Letter of Intent

Re: Eldorado Springs Apartments, TSN # 6433300012

February 20, 2020

LANDSCAPE PLAN
SDP5
SHEET 5 OF 16
ALC PROJECT #19-020

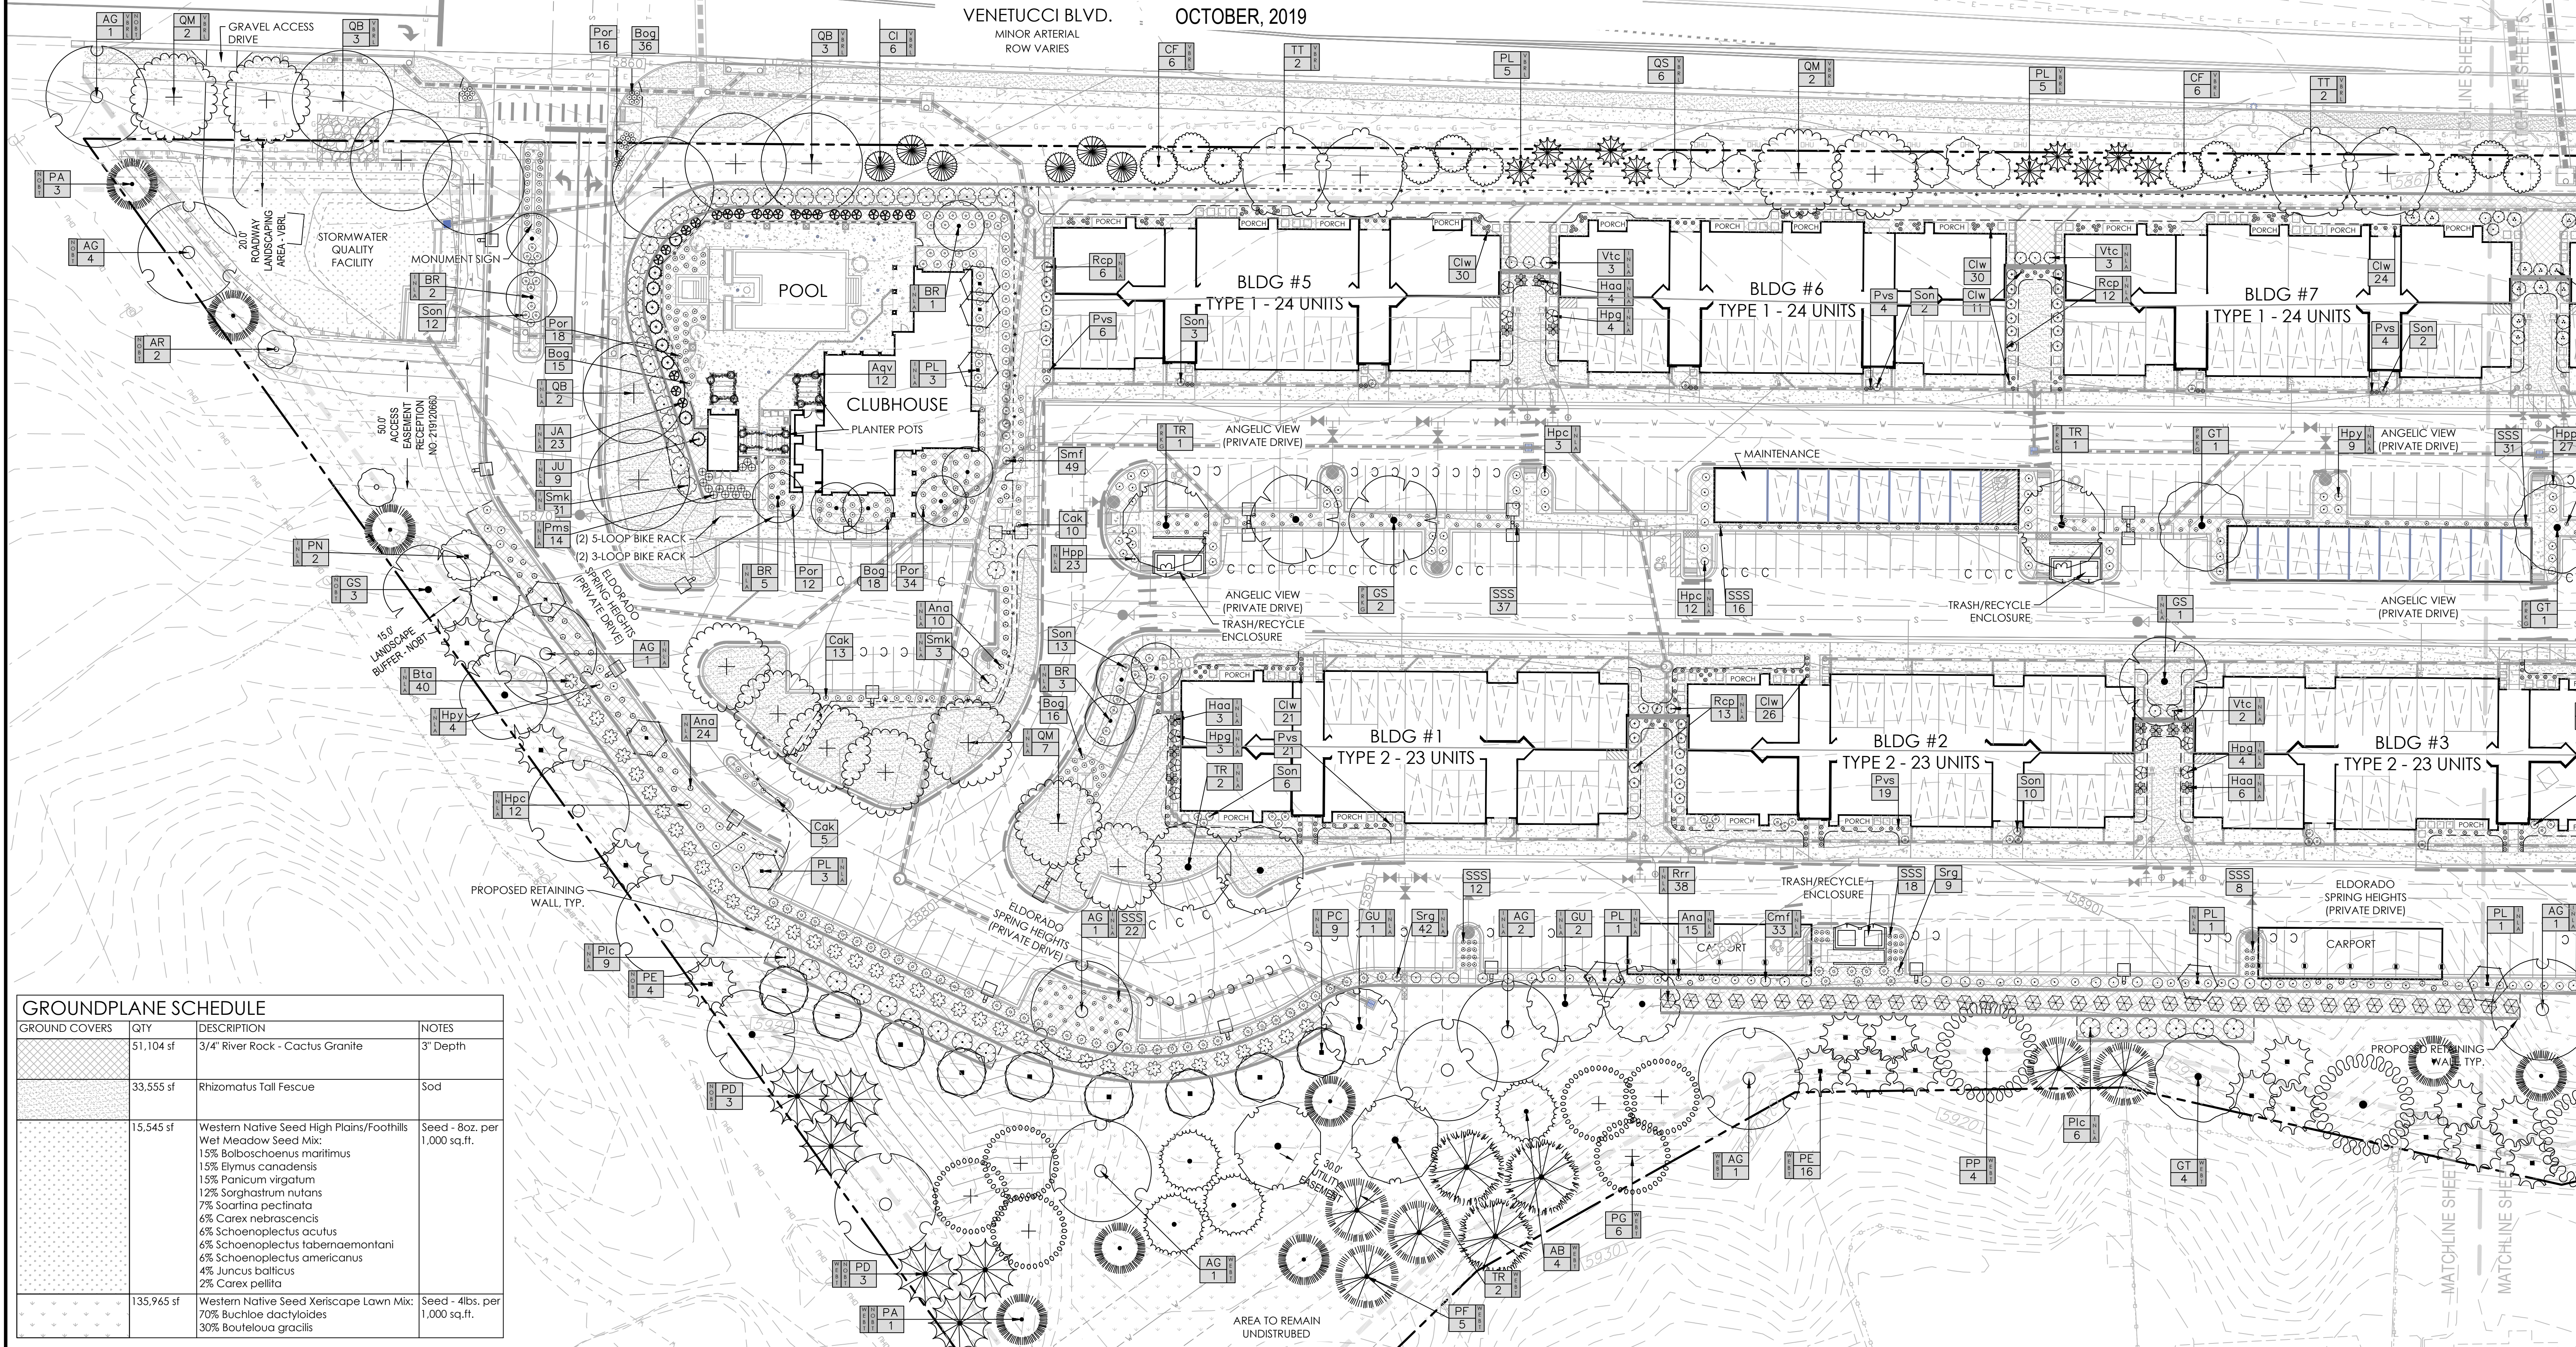
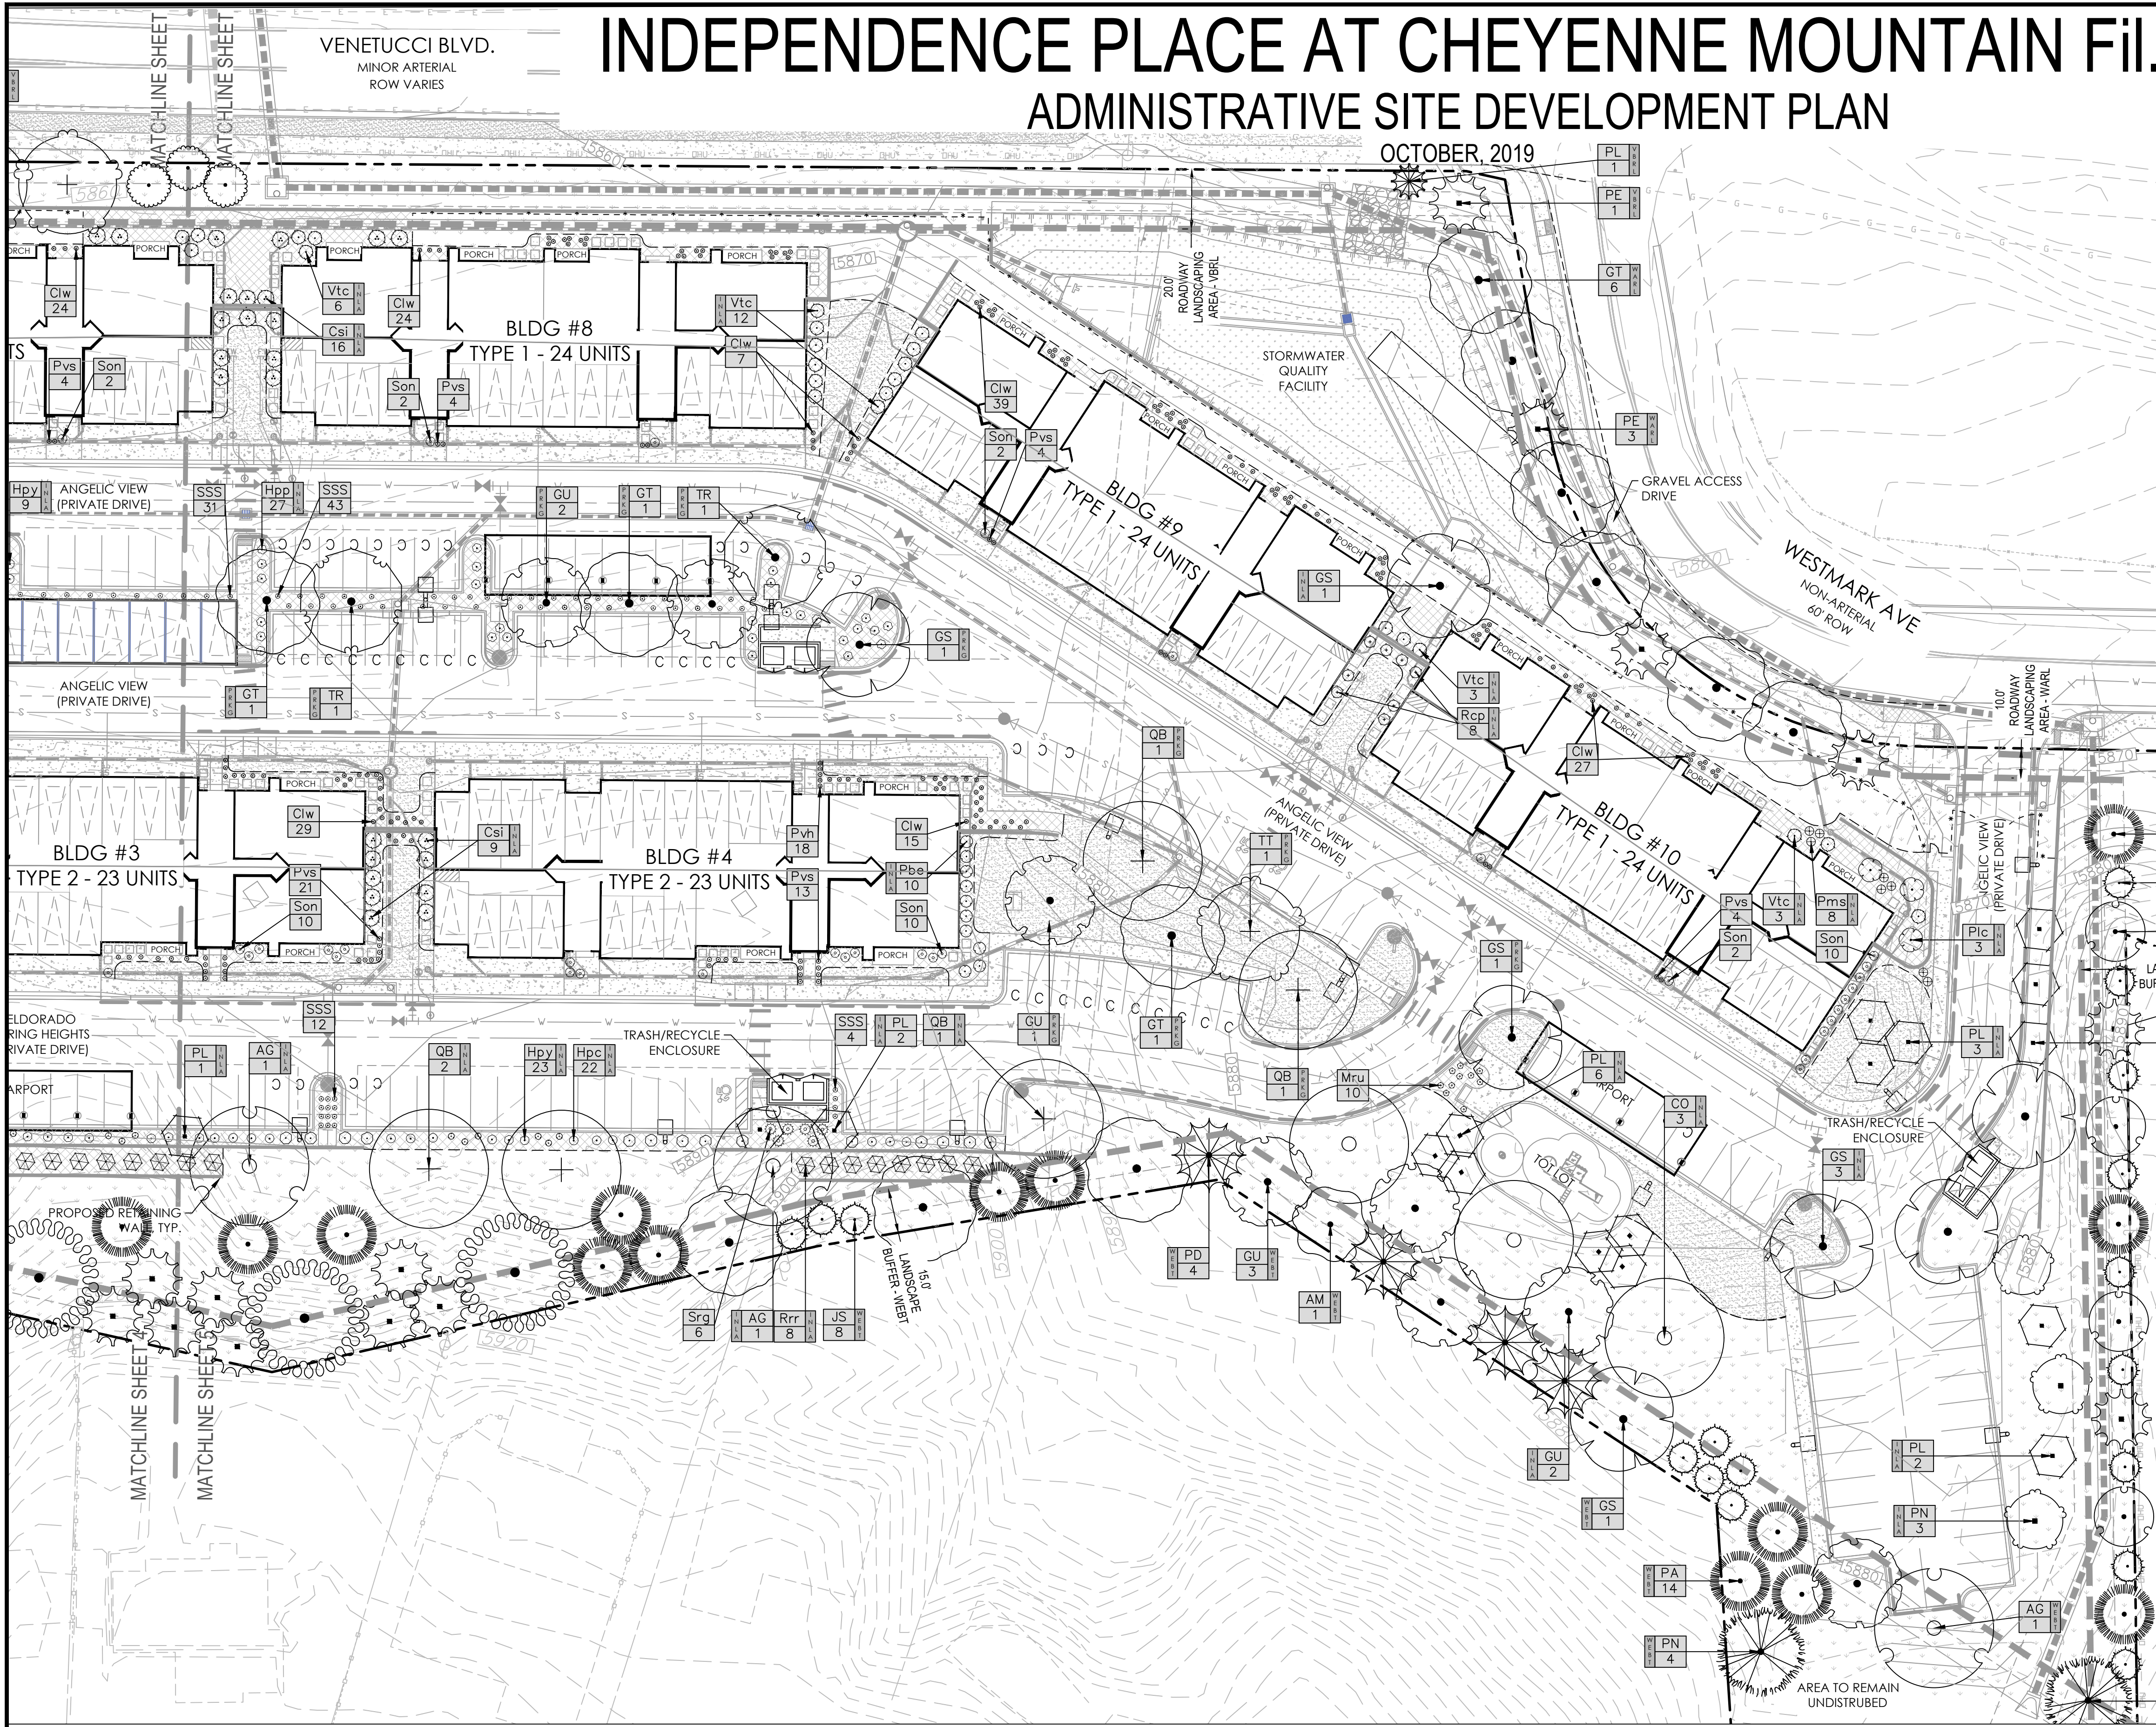
The director is still considering, however, rendering and justification needs more detail, eg, what will the caliber of the tree be at time of planting, when is maturity estimated, etc.

Response: Letter of Intent has been updated with a more detailed justification. Please also reference the Buffer Section graphic, which is included in the resubmittal.
